**Southern
Water**

Date
01/04/2021

Proposal: Approval of details reserved by condition following Y/32/17/OUT relating to conditions 6-scheme to deal with the risks associated with contamination of site, 7-drainage strategy details, 8-surface water drainage scheme, 10-SuDS system, 19-lighting details & 23-details & timetable of decentralised & renewable or low carbon energy resources.

Site: Y/25/21/DOC: - Cinders Lane Nursery and Works to The Rear Cinders Lane, Yapton, BN18 0JJ.

HB2, Hydro Brake Manhole & Discharge from Sub Base Attenuation Details

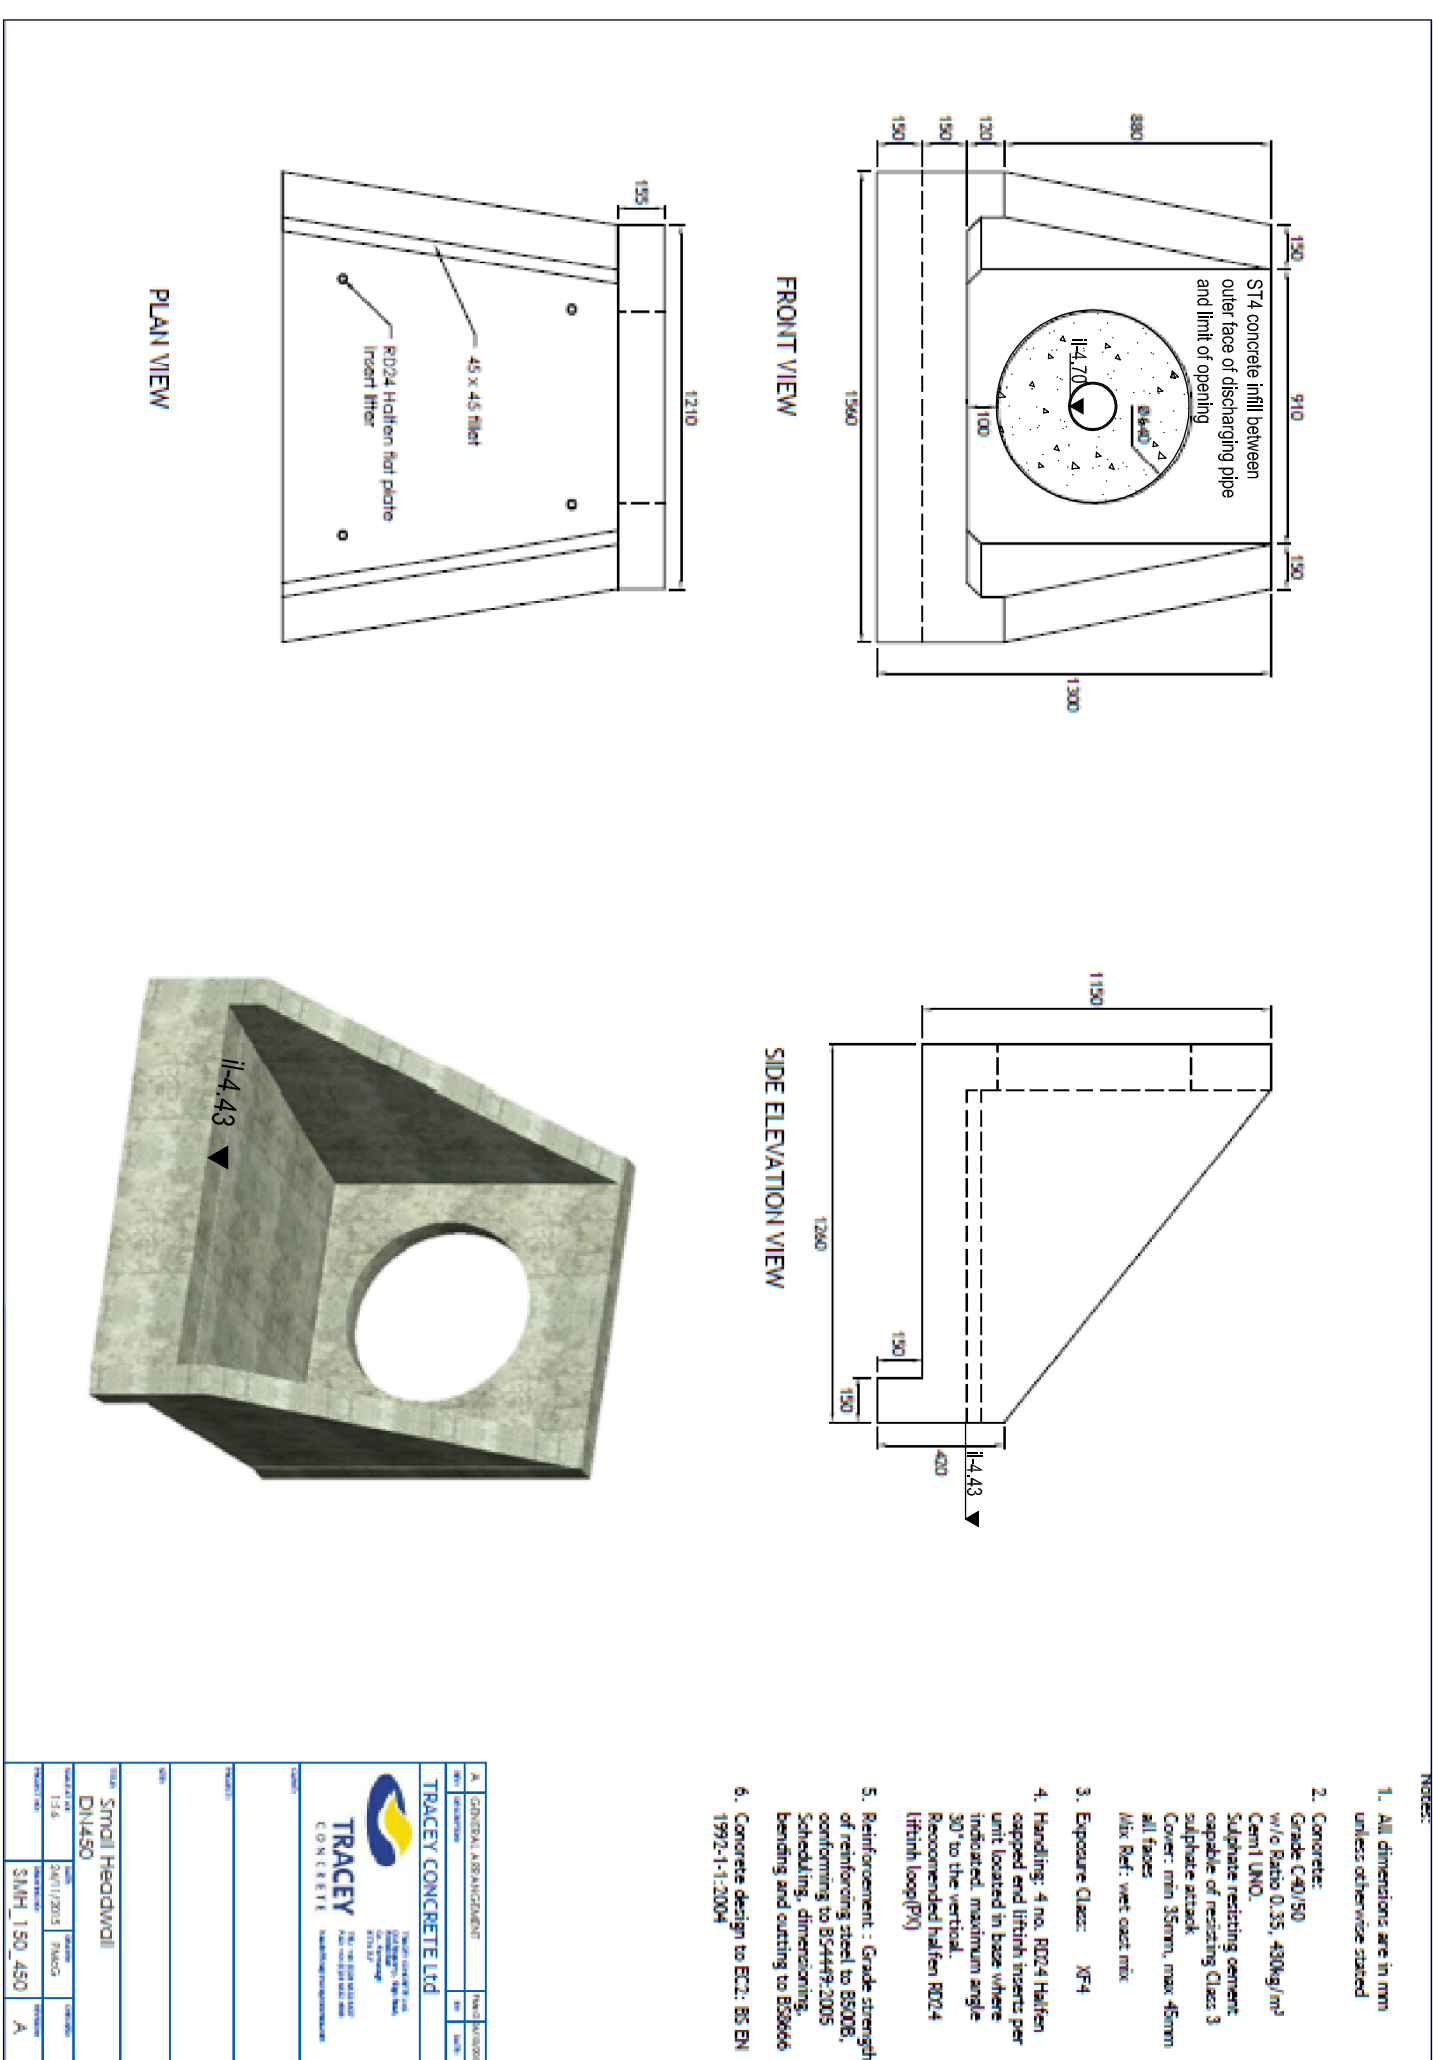
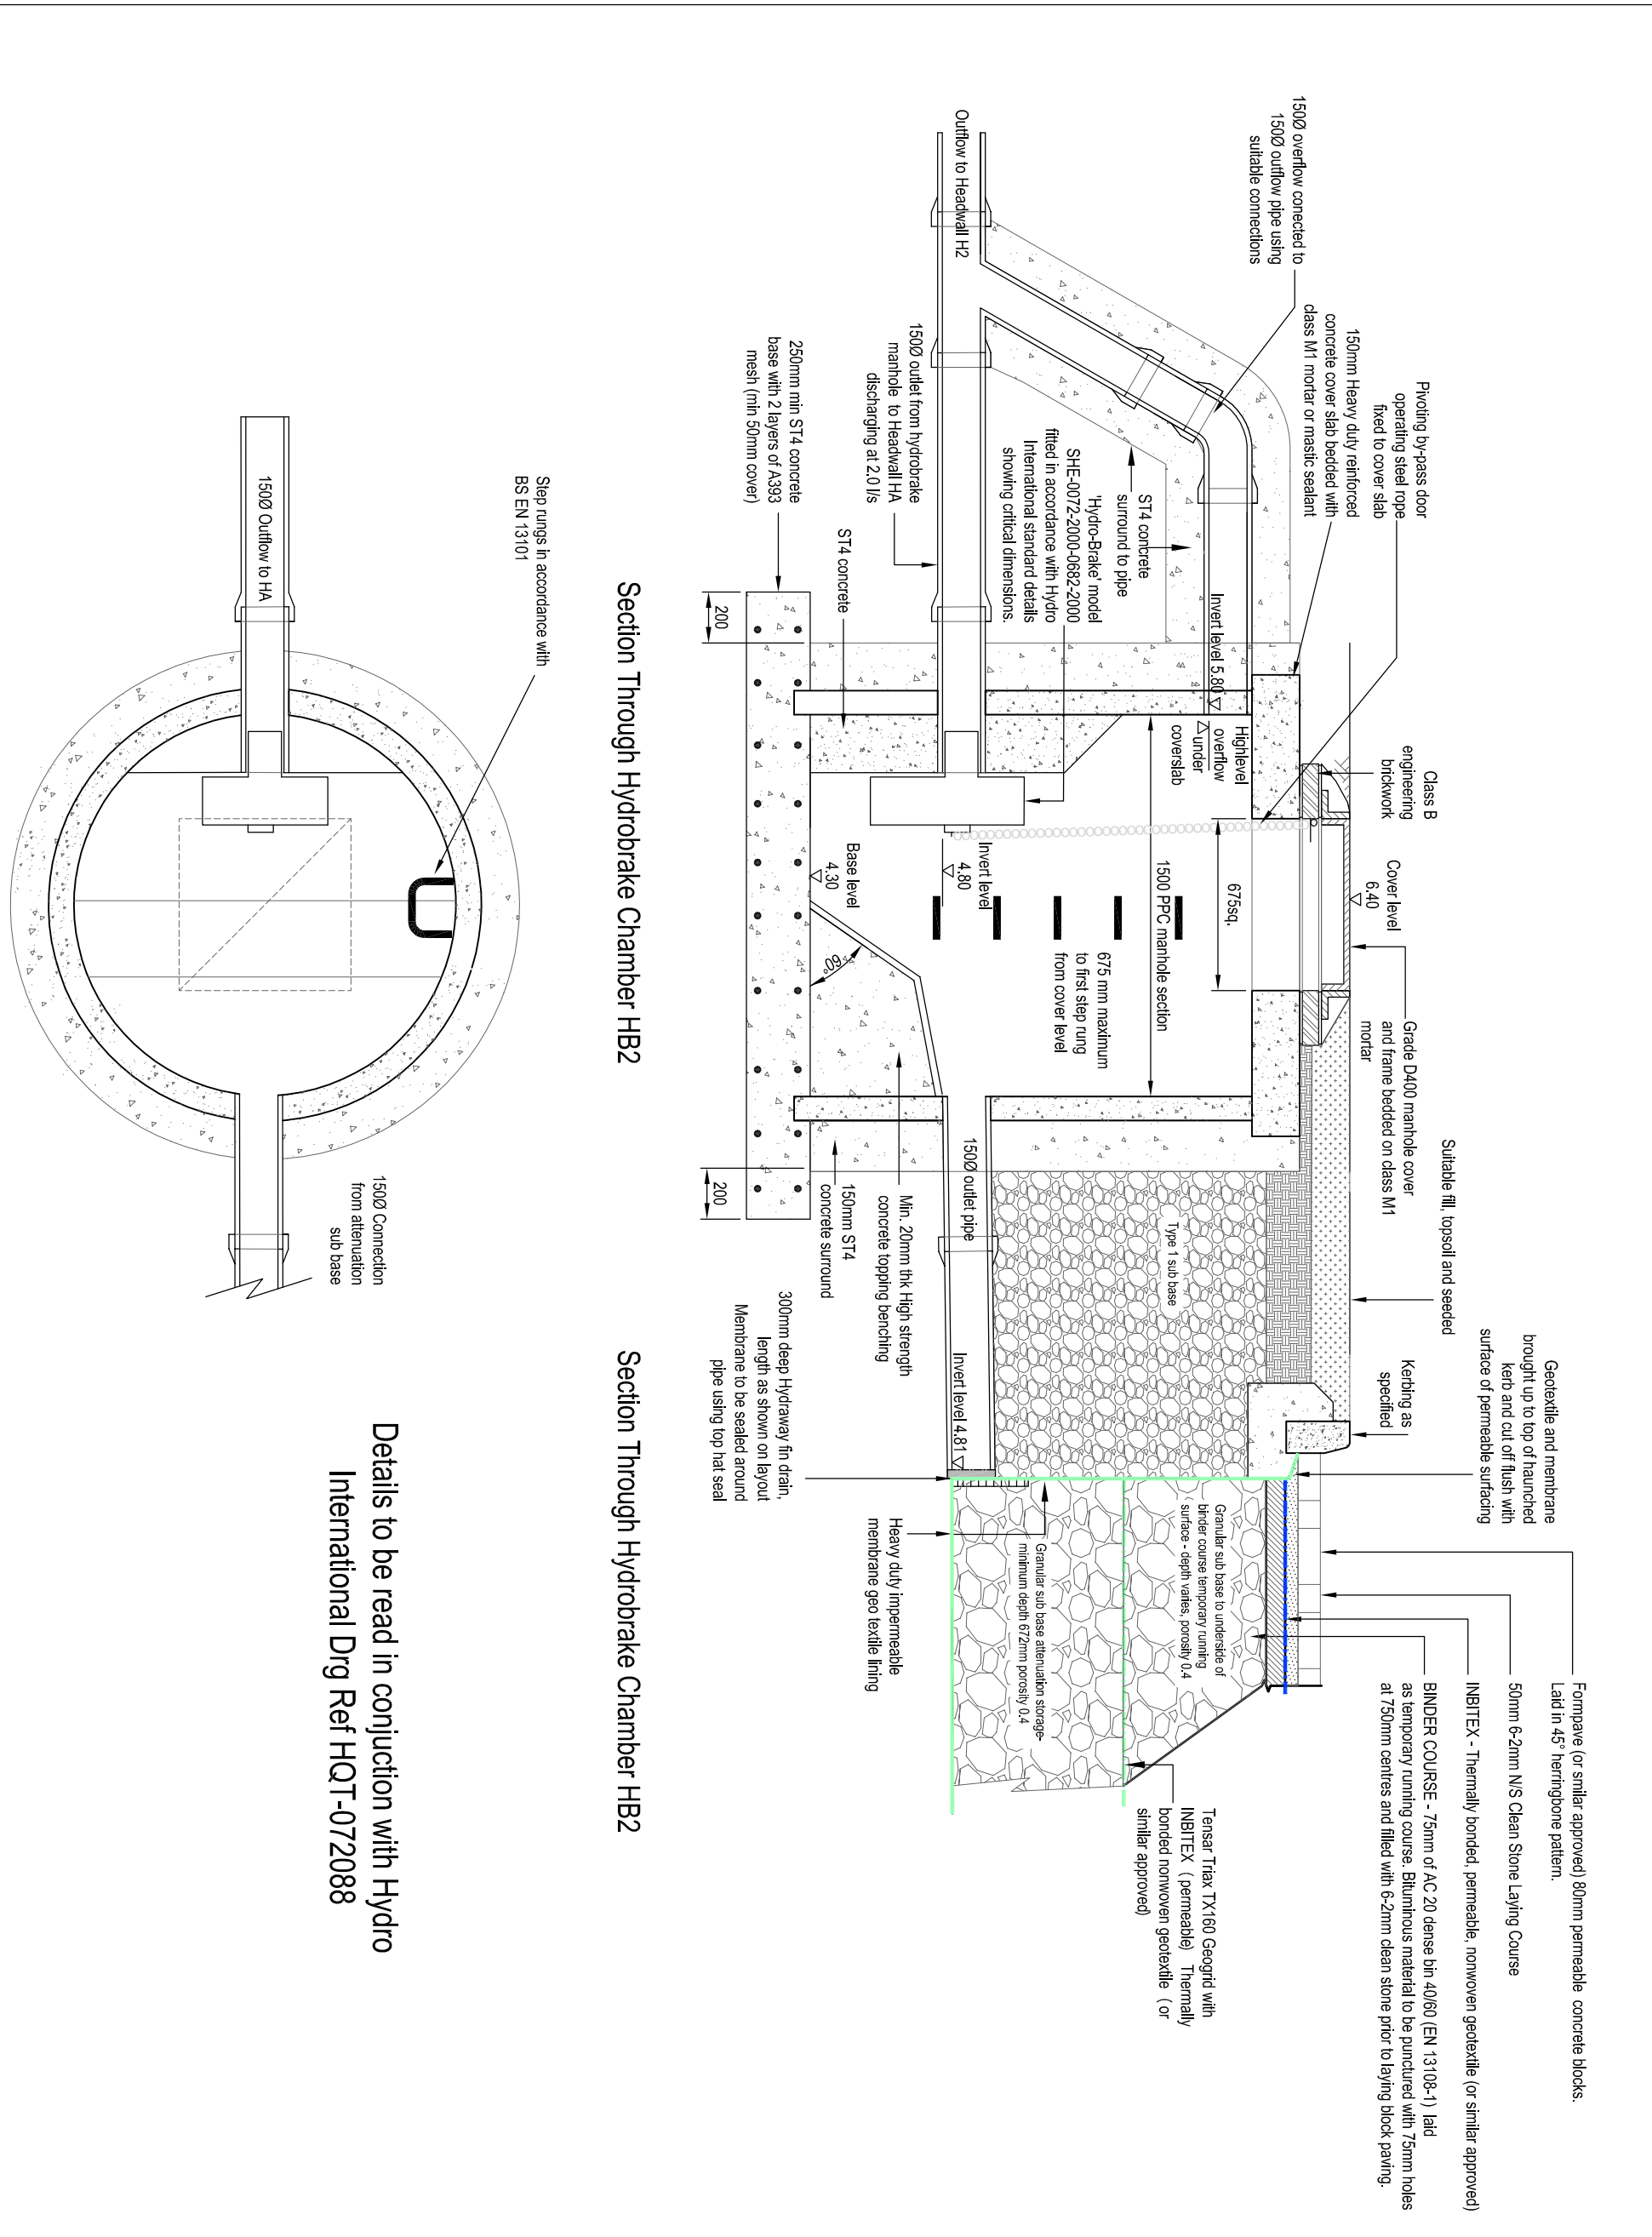
Please note that as there could be a risk issue, please ensure that to install vent on the storage tank to prevent H₂S&CH₄.
